COMMUNITY DEVELOPMENT DEPARTMENT  
80 Columbia Avenue ♦ Marysville, WA 98270  
(360) 363-8100 ♦ (360) 651-5099 FAX

Re: Marysville Corporate Center – *Technical Review 1*  
PA 22004

RE: Marysville Corporate Center, File# PA22-004  
Binding Site Plan  
15908 47<sup>th</sup> Ave., Multiple Parcels

S02°47'21"W 1300.05' (C) 1300.04' (R)

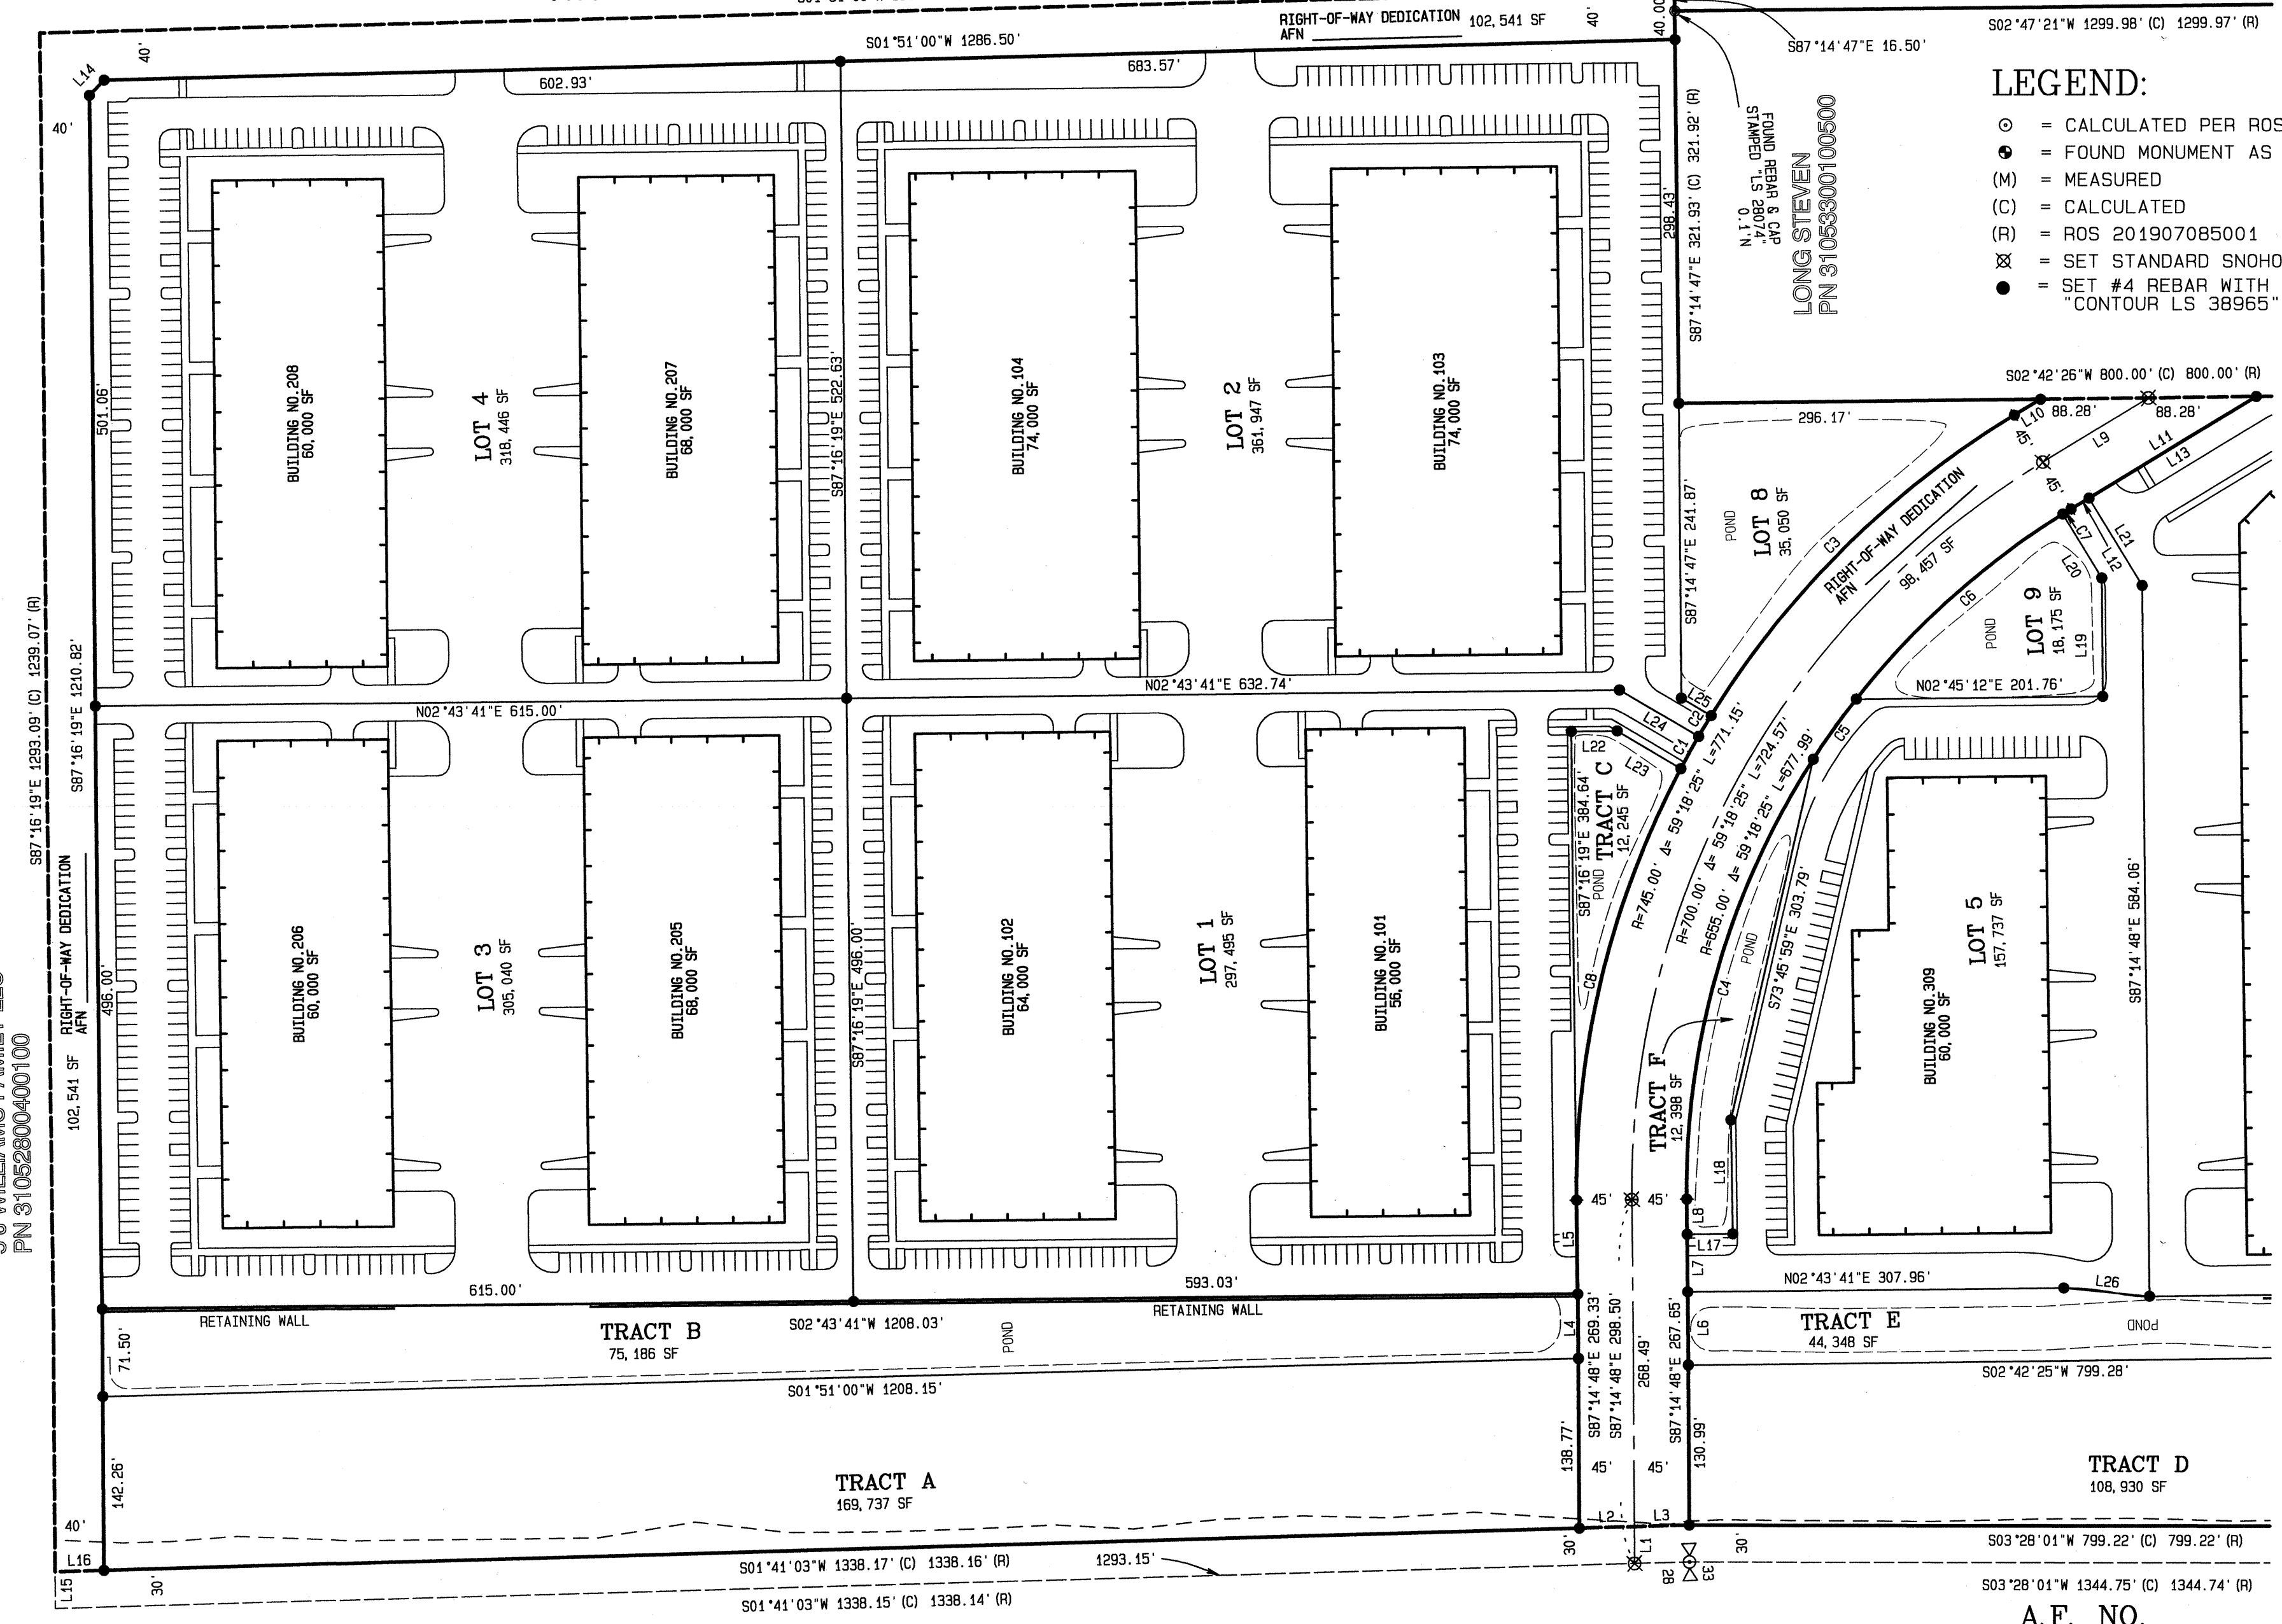
4. The preliminary BSP submitted is essentially a Final BSP. A preliminary BSP shall be required to be submitted, which includes the following information, as outlined in MMC 22G.100.090(3):

- a. See [MMC 22G.100.090\(3\)\(a\) – \(o\)](#) for all elements required to be depicted on the preliminary BSP. Most are included in the “Final BSP” submitted but will also need to be included on the preliminary BSP.

- b. Cover sheet should show entire boundary of site, including phasing lines.
  - c. Subsequent sheets shall be drawn in a reviewable scale (i.e. 1” = 20’, 1”= 30’, 1”= 40’ or 1” = 50’), pursuant to [MMC 22G.100.090\(3\)\(b\)](#).

- d. Phase 1, including all lots and tracts for all phases, shall be drawn with **dark solid lines**. With the recording of Phase 1 all lots will be created, however, individual site plan review will be required for development of subsequent phases.

- e. The interior layout of Phases 2 & 3 shall be drawn in **light colored shadow print**.
  - f. An existing conditions sheet will need to be provided, which depicts all encumbrances outlined in Schedule B of the Title Report prepared by Chicago
